Approval of details reserved by condition under WA/108/24/PL relating to condition 3- Surface Water Drainage.

Stoneybrook Farm Eastergate Lane Walberton BN18 0BA

Arun District Council have decided to **REFUSE details reserved by condition for the following reasons:**

Proposed Surface Water Drainage
Watercourse and Pond Sections

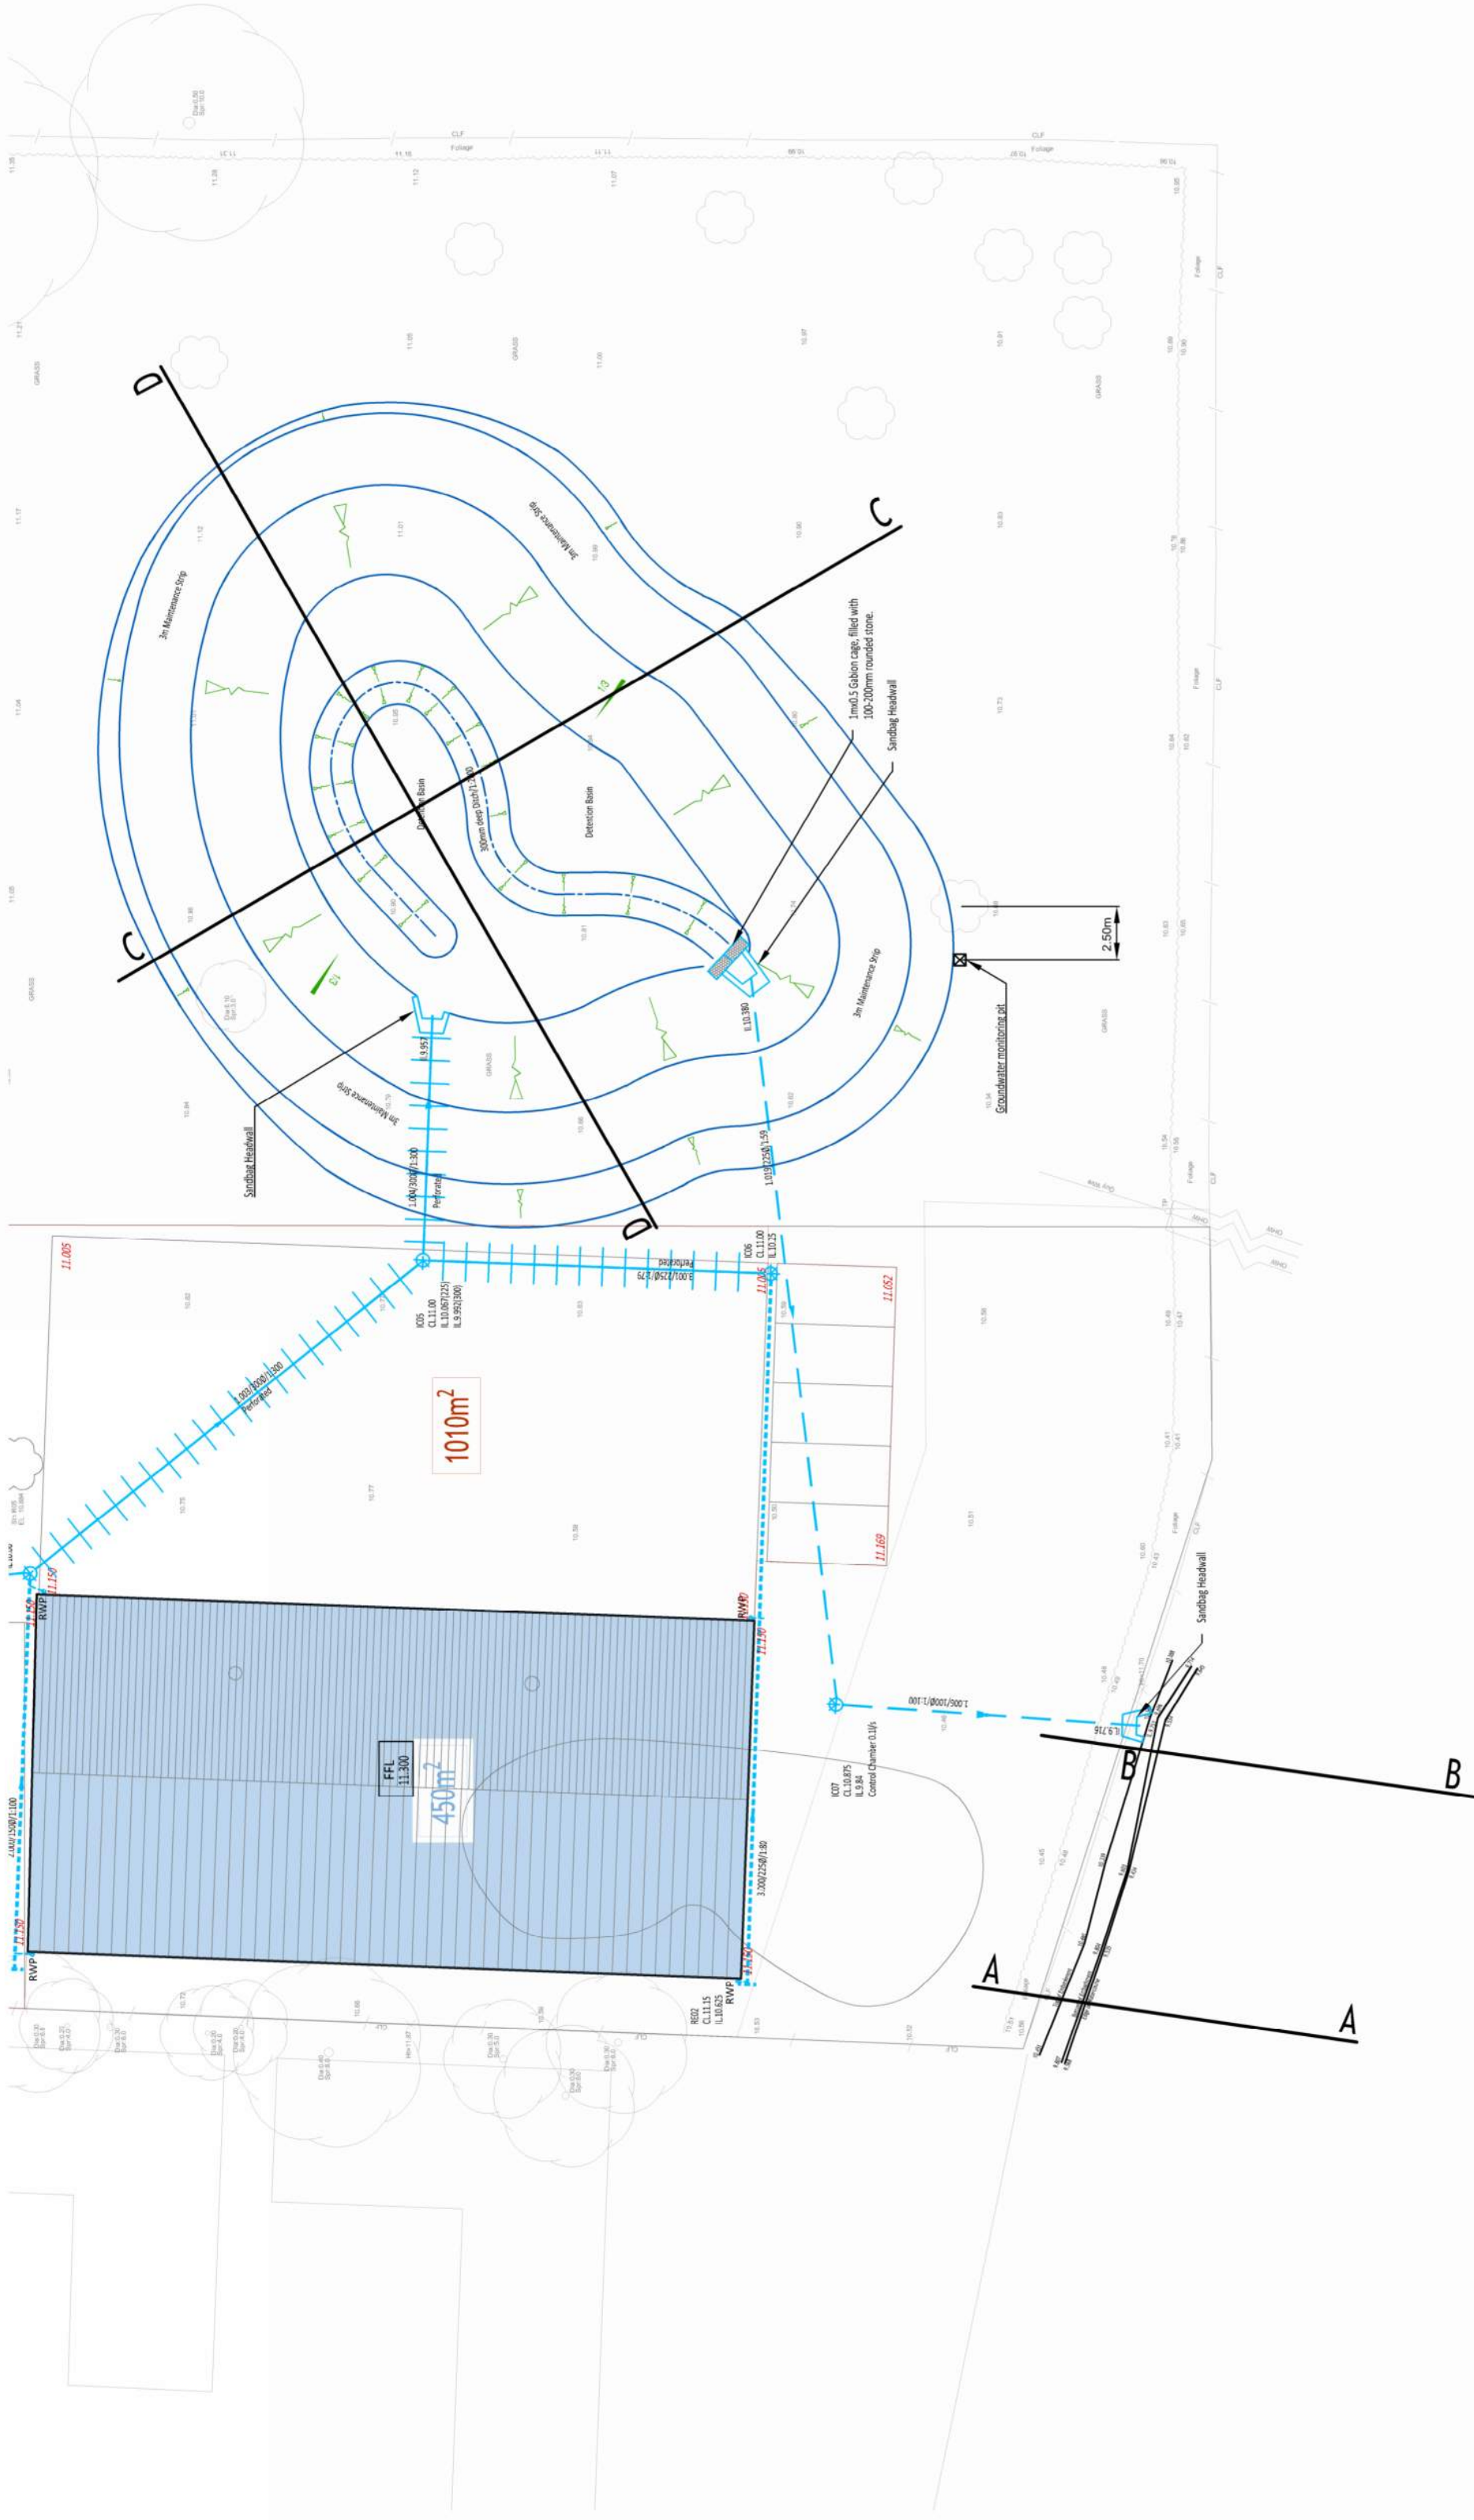
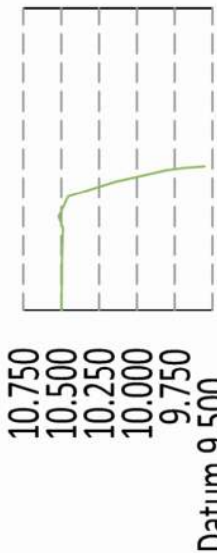
- Calculations should be provided for the area served by the attenuation basin (pond).
- Construction details for the basin construction and liner need to be amended.
- Details should be provided for the flow control chamber to include blockage protection.
- A surcharged level should be specified.
- Evidence of Ordinary Watercourse Consent from the LLFA or Land Drainage Bylaw Consent from ADC is required.
